DARWIN
ECOLOGY

29th December 2020

Darwin Ecology conducted a Preliminary Ecological Appraisal (PEA) at land at the former McIntyre Nursery, Worthing on 6th November 2020. Although no habitat suitable for roosting bats was observed on the site, the rural surroundings provided roosting, foraging and commuting habitats. The plans are to use the site for rented storage units which will be accessed by clients, subsequently a lighting plan has been created by Standby Self Storage Ltd and reviewed by Darwin Ecology.

The approved lighting plan (Standby Self Storage / John Collins Associates Drawing Number 5320-2 Rev D (December 23rd 2020)), sent to Darwin Ecology on 23rd December 2020, includes various features to reduce the affect lighting may have on bats including:

STATUS	CLIENT		
Outline Design	Standby Self-Storage		
SCALES	DATE	SIZE	
1 : 200	Sept 2020	A2	
TITLE			
PROPOSED SITE & BLOCK PLAN			
DWG NO			REV
5320-2		d

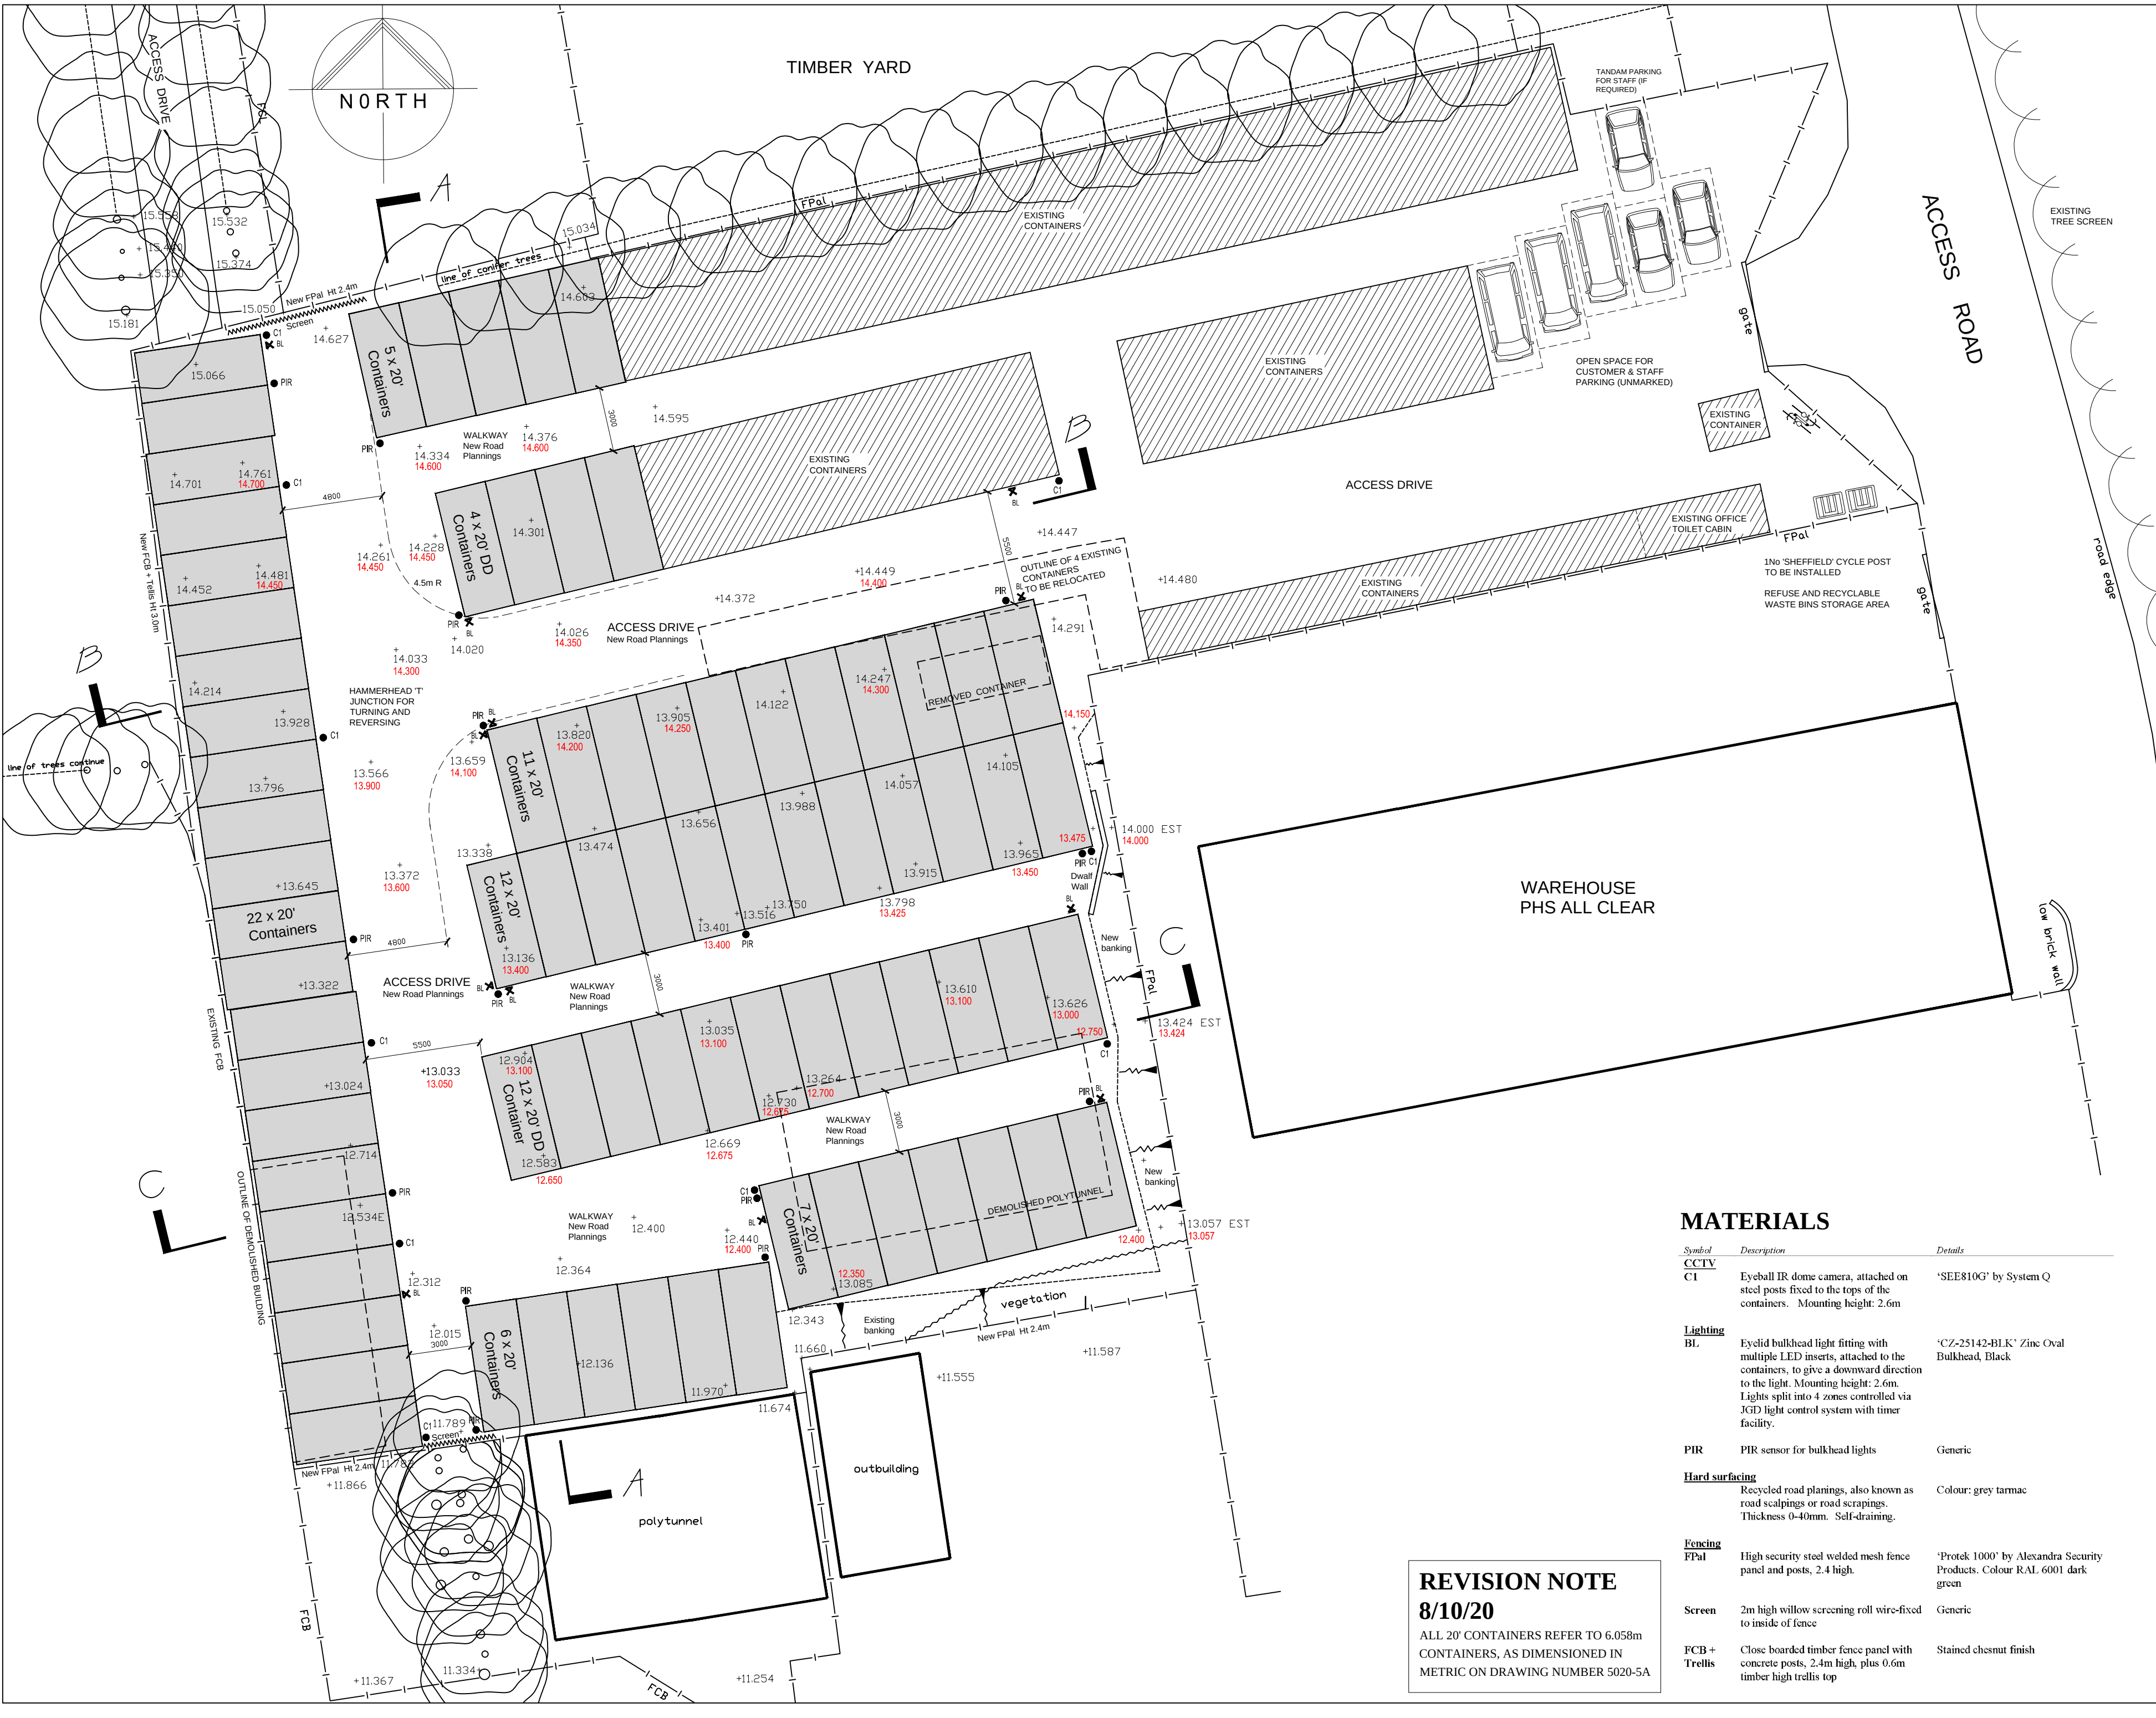
- The use of Zinc Oval Bulkhead Black 240v lights which are fitted with 'eyelids' covering 50% of the light. Lightbulbs to be used with these will produce a 'warm' light with a temperature of less than 2700K;
- The lights will be off during closing hours (opening hours are 07:00 - 19:00 Monday to Saturday and 07:00 - 17:00 on Sundays) and will be operated by Passive Infra-red (PIR) sensors ensuring the lights are only on when movement is detected. These sensors will be adjusted to ensure movement of wildlife does not trigger the lights;
- The site will be split into multiple zones using a JGD light control system to guarantee that only the lighting necessary for the person(s) to access their storage unit(s) will be switched on;
- A minimum number of lights are being installed with only one light being fitted on each corner;

- Lights will be installed at the top of the containers and no higher in order to reduce the amount of light spilling above the height of the containers;
- Dark coloured paving and containers will be used to reduce the amount of reflected light;
- Fencing in the north western corner of the site will be installed with willow screening to block any additional light onto the surrounding habitat from cars accessing the site.

As long as this scheme is implemented in full we believe it to be a suitable balanced solution that will negate any adverse effects caused by lighting of the proposed storage facility on local wildlife, especially bats. Any further modifications or additions to this system would need to be reviewed in full by a licensed ecologist.
